**MODIFICATION REQUEST:
Residential and Child Care Centre
Development
14-18 Boondah Road Warriewood
MP10_0177 MOD 9**

Director-General's
Environmental Assessment Report
Section 75W of the
Environmental Planning and Assessment Act 1979

July 2012

BUILDING E PLANS & ELEVATIONS
SCALE 1:200

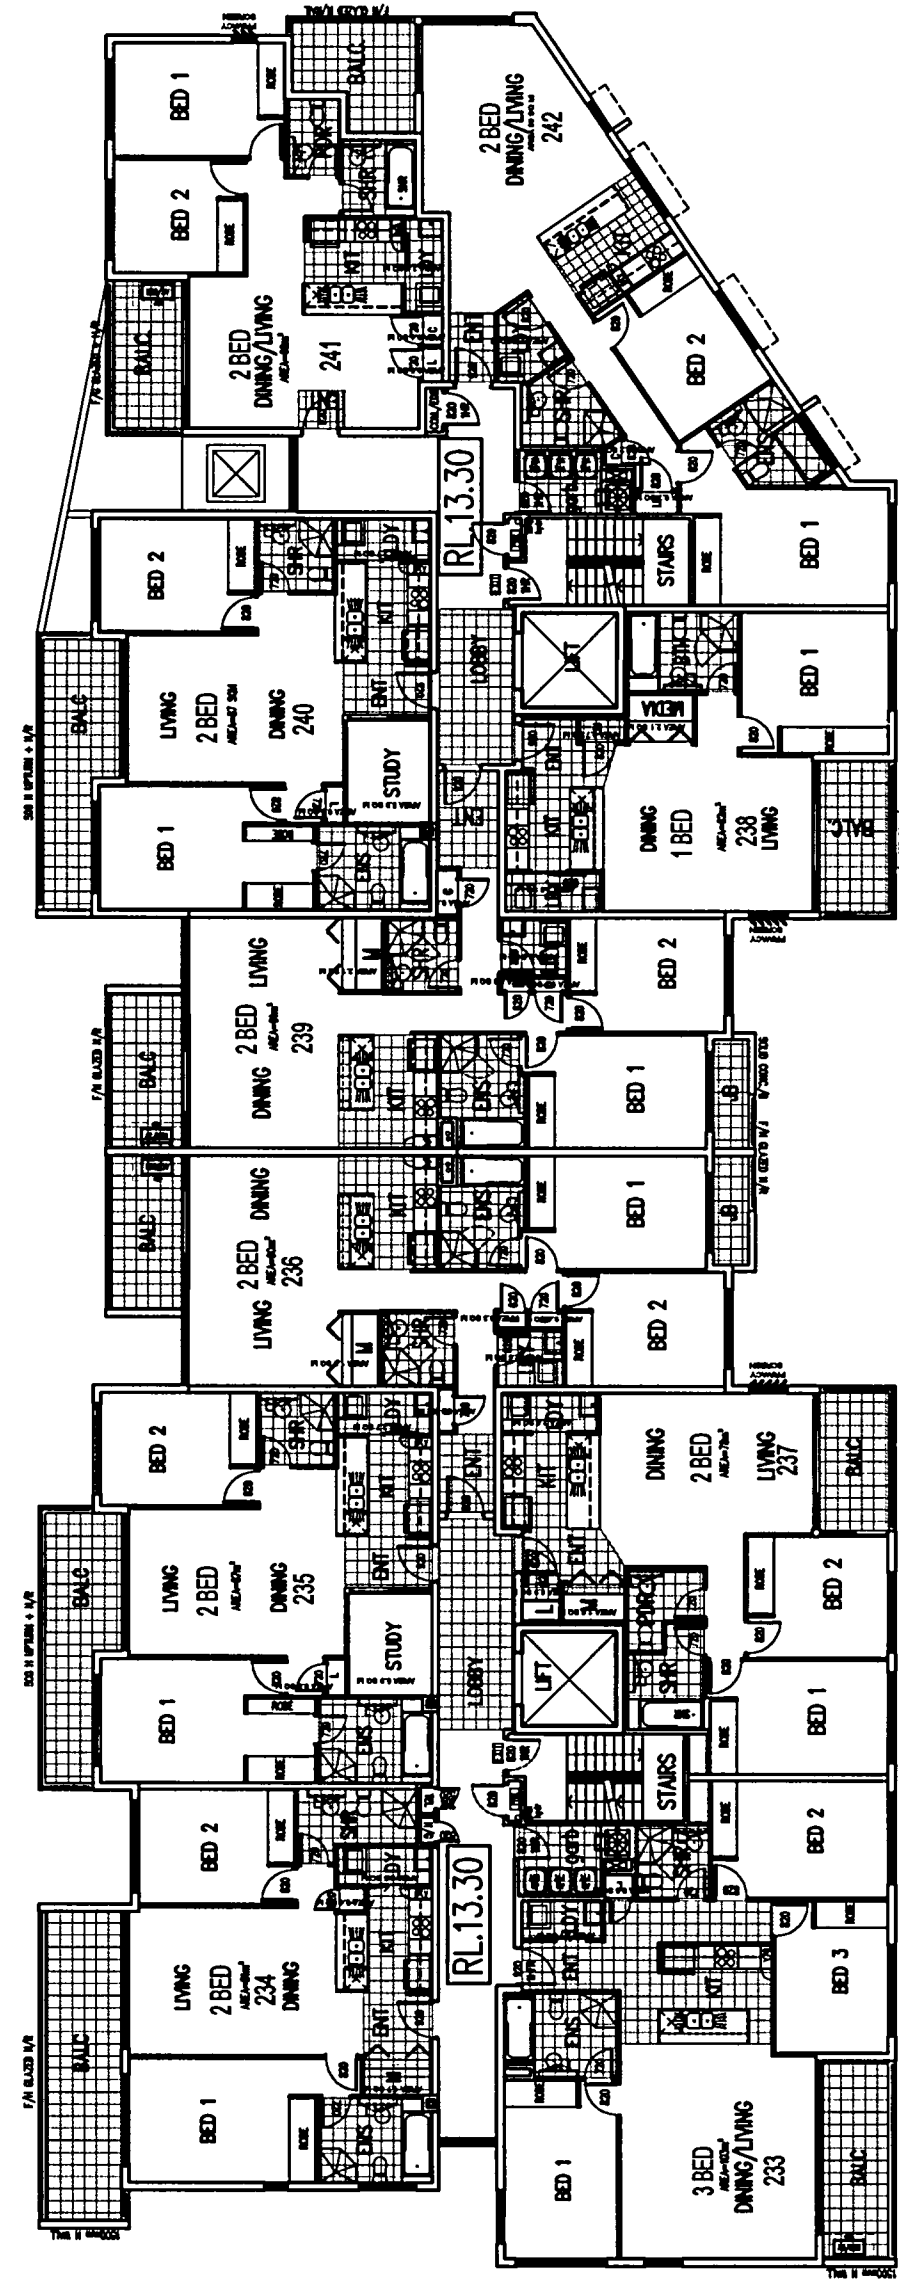
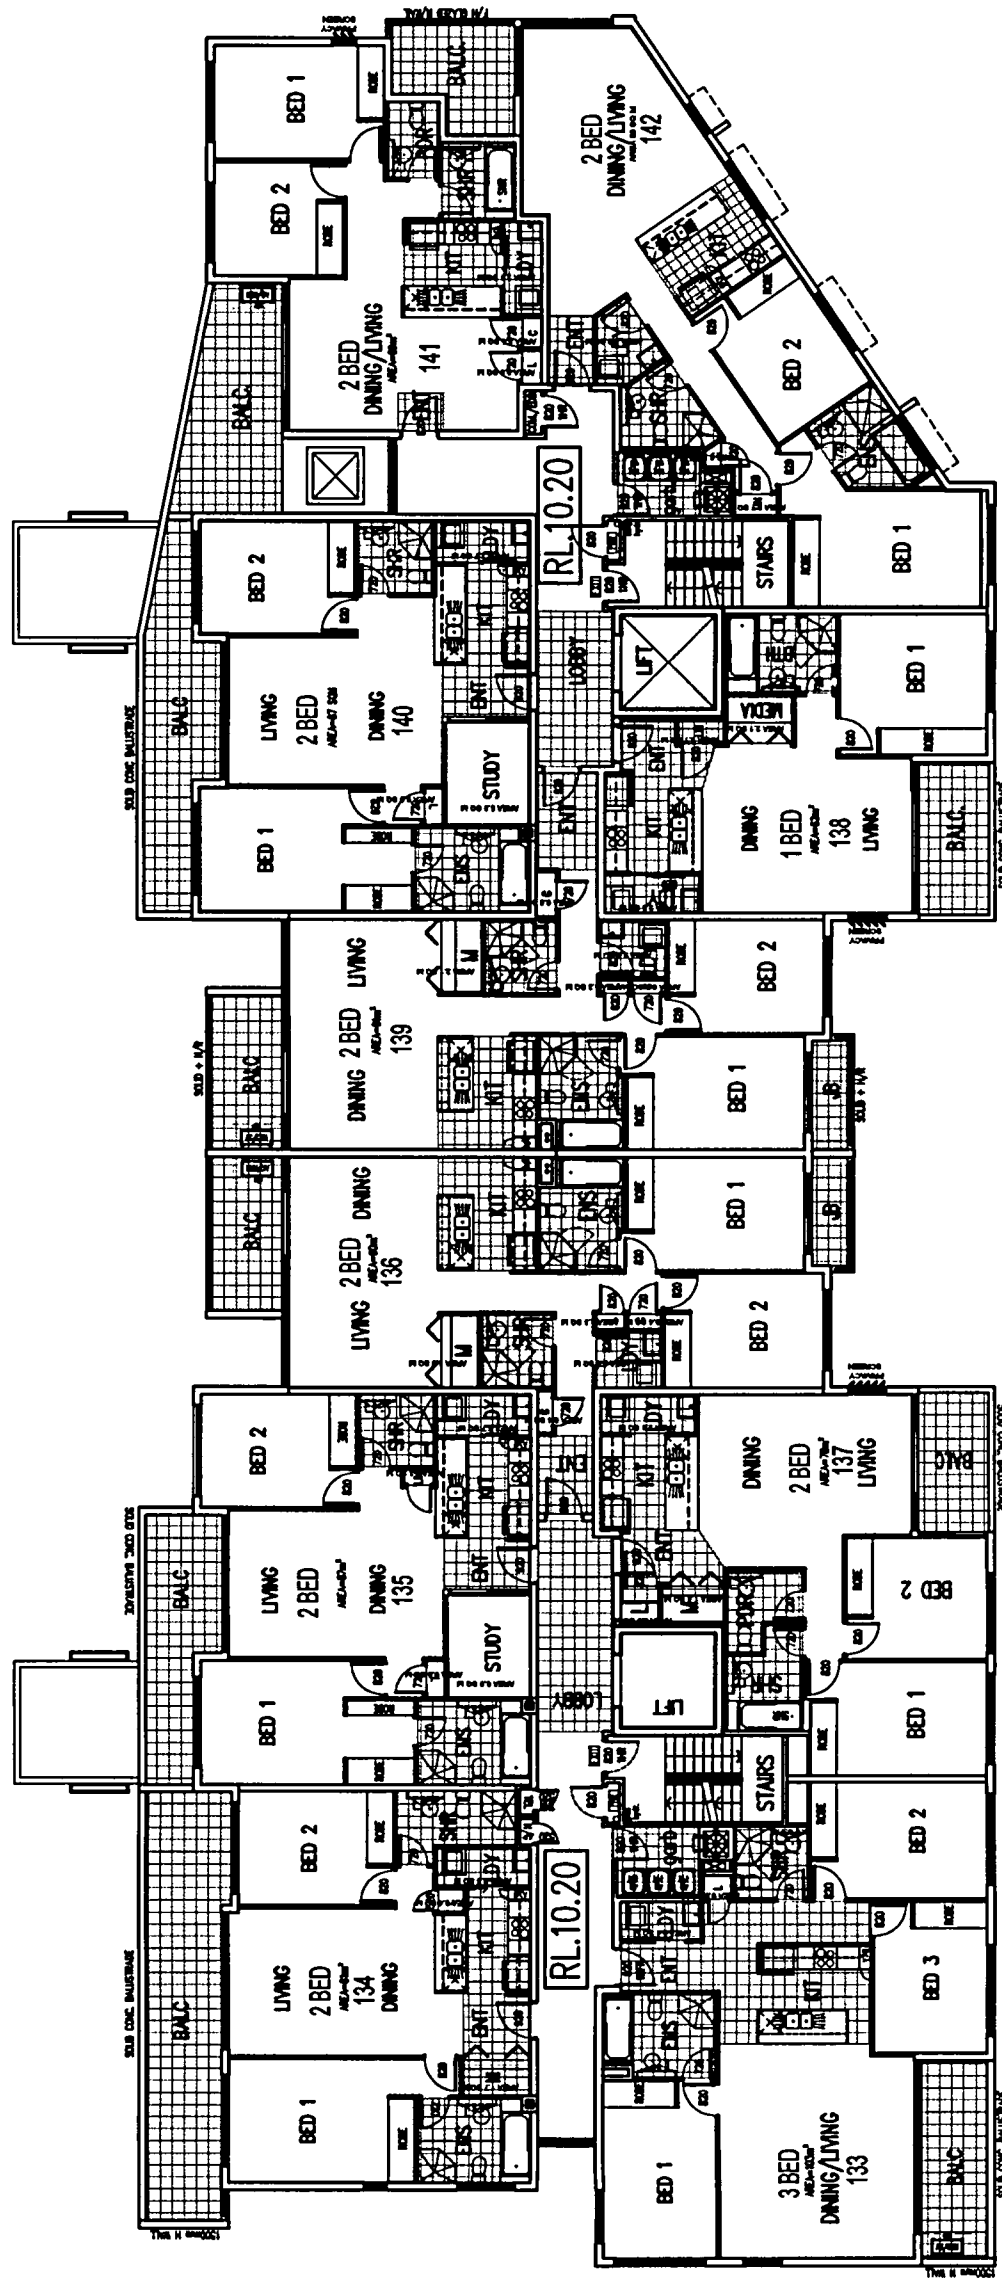
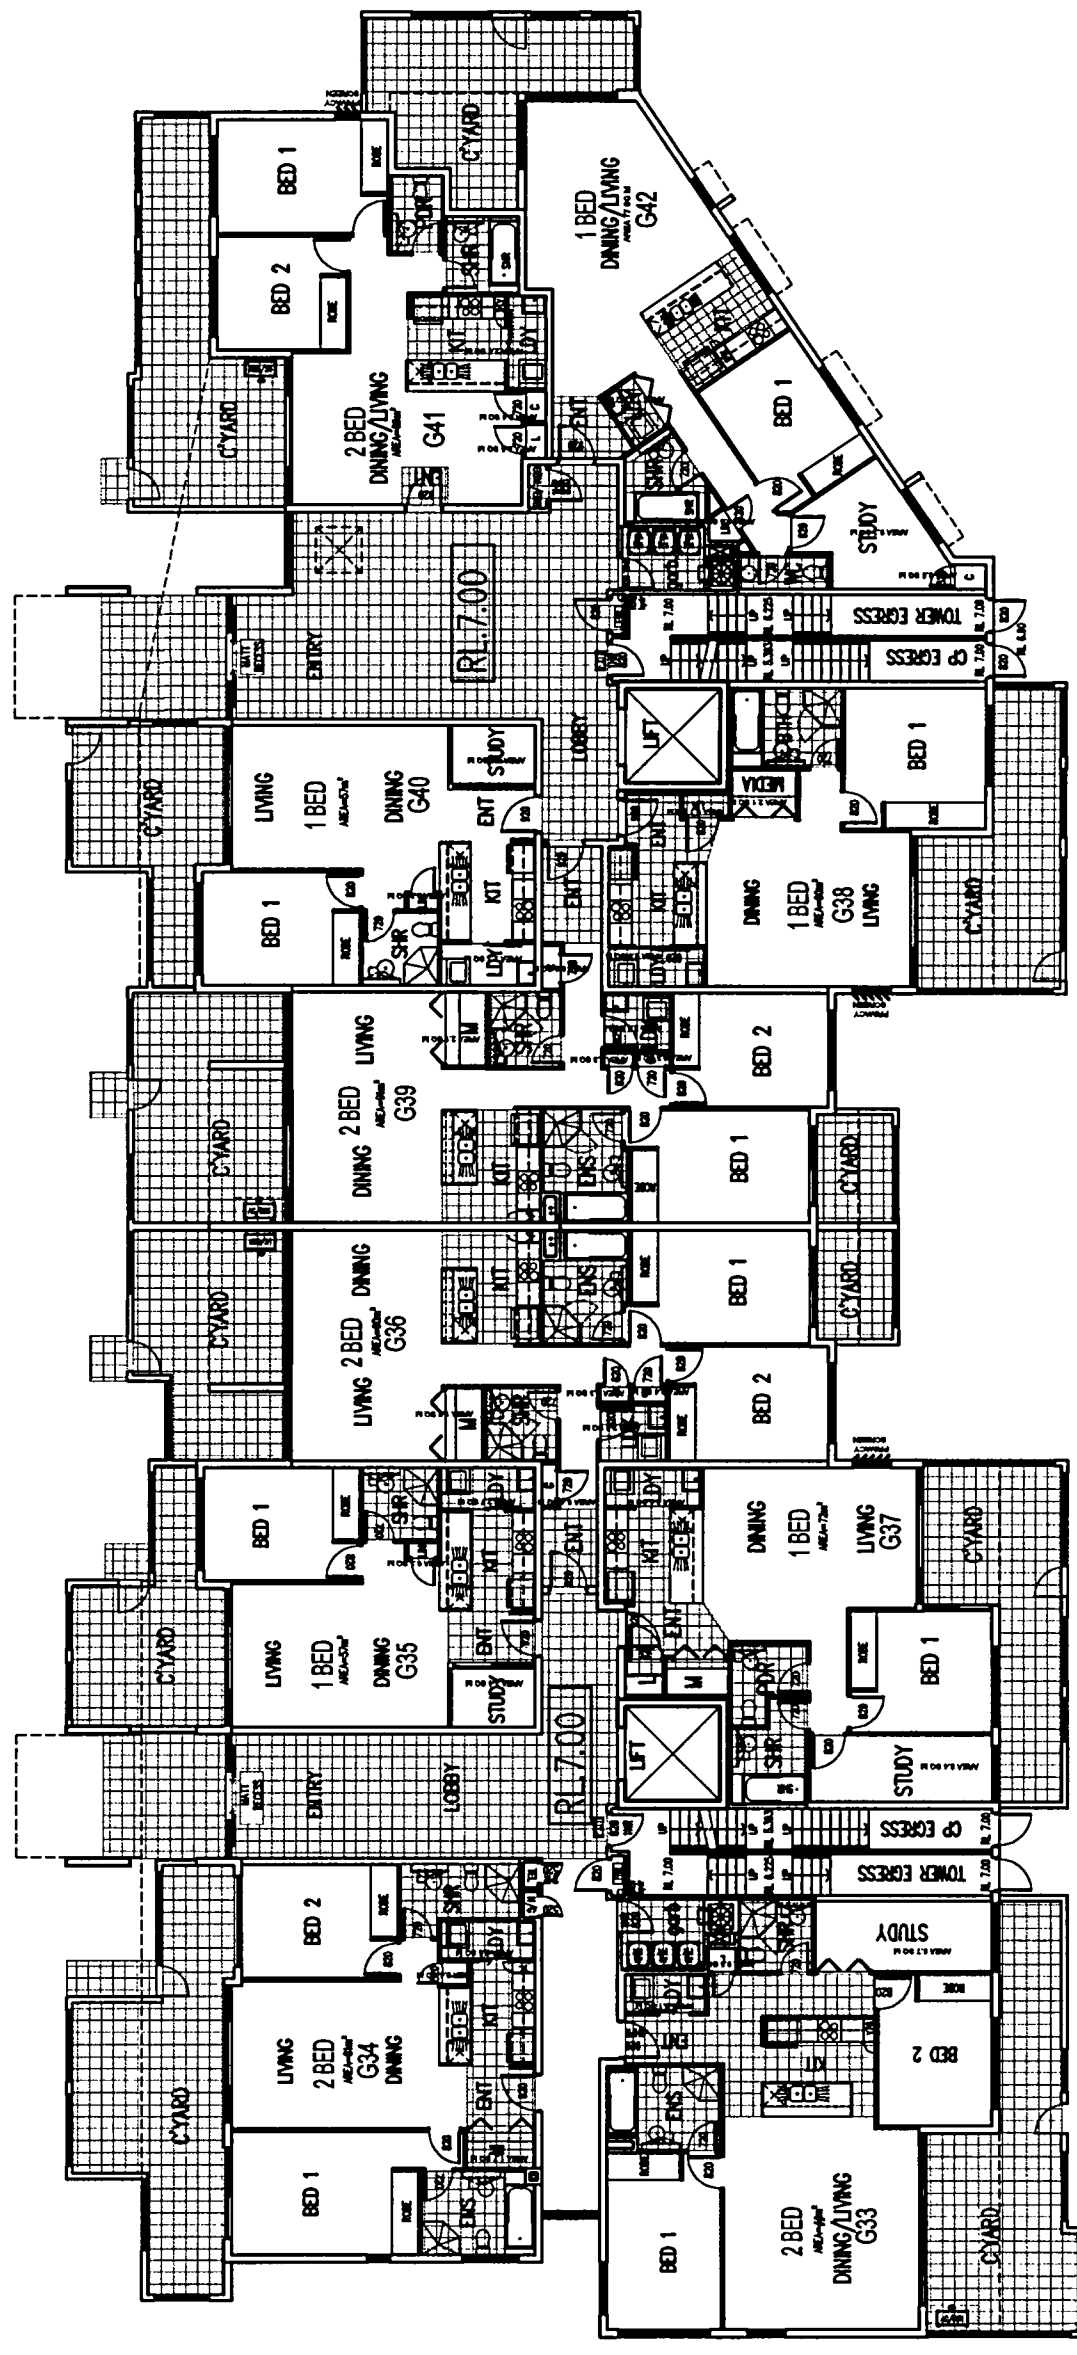
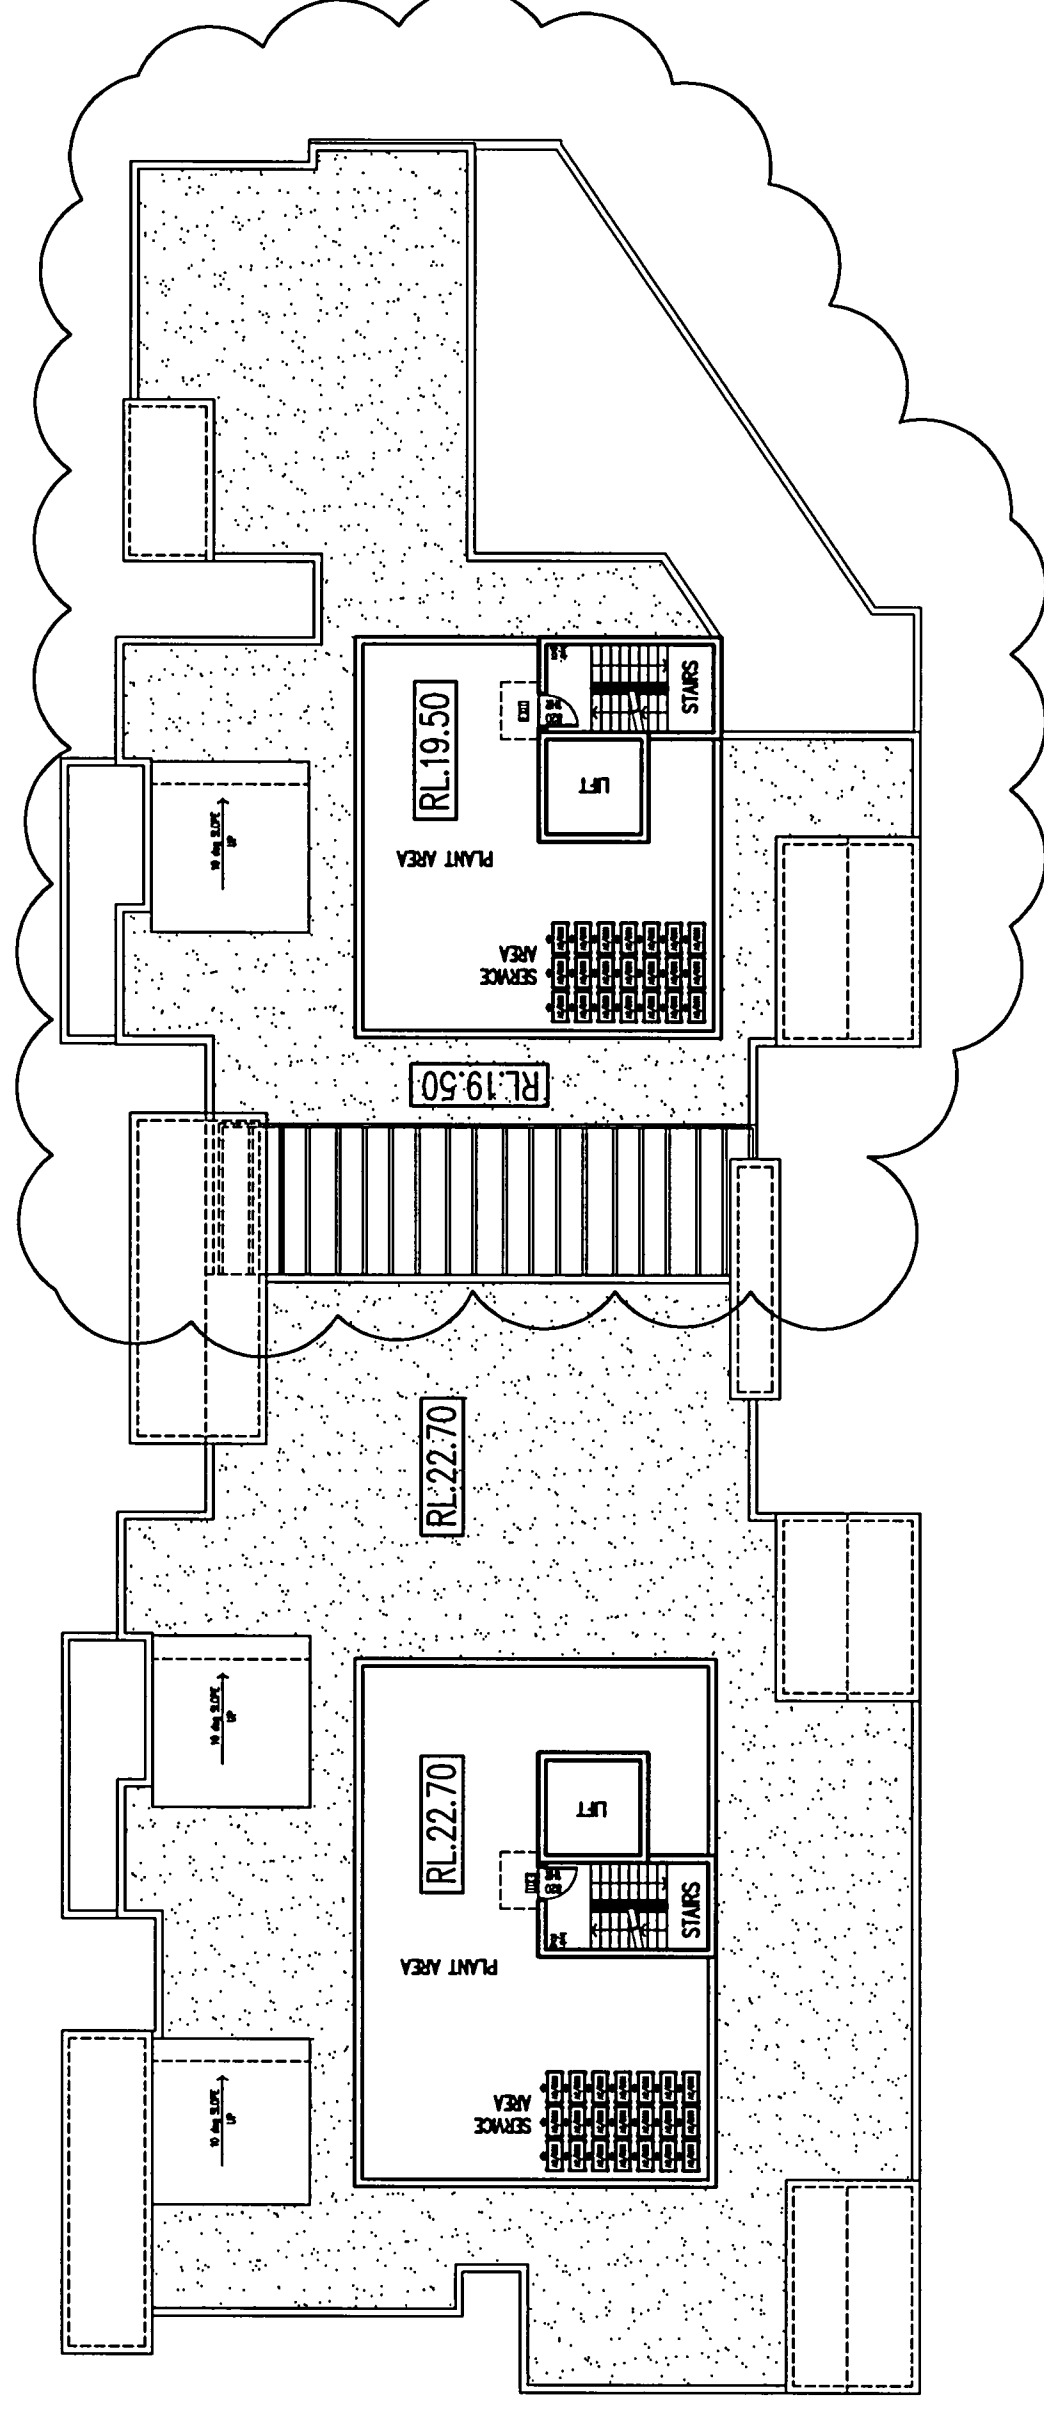
- will not result in the study areas being able to be converted into additional bedrooms that in turn require additional car parking spaces; and
- are in accordance with the BASIX certification.

A total of eight studies are proposed in units to Buildings E and G ranging in floor areas of approximately 5m² to 10.4m².

The Department does not consider the conversion of studies to bedrooms or the resulting parking requirements to be a significant issue based on the size of the studies and the rates that apply to unit types. This issue is further discussed under Section 5.1 of this report.

- the proposed studies are generally not conducive for use as bedrooms due to their dimensions (5-10m²);
- only two out of the eight studies proposed are of a sufficient size to present a possibility to be used for anything other than a study or for storage purposes. These studies are contained in Unit 335 of Building F and 361 of Building G;
- should the two studies in Units 335 and 361 be converted into additional bedrooms, it would have no implications on parking requirements given these two units are approved as 2 bedroom units and the rate remains constant for units that contain two or more bedrooms; and
- the proposed studies will not change the bulk and scale of the development and gross floor area will remain unchanged.

With regard to the proposed studies, the proponent has stated that they are identified as studies on the approved plans and any change will be a non compliance.
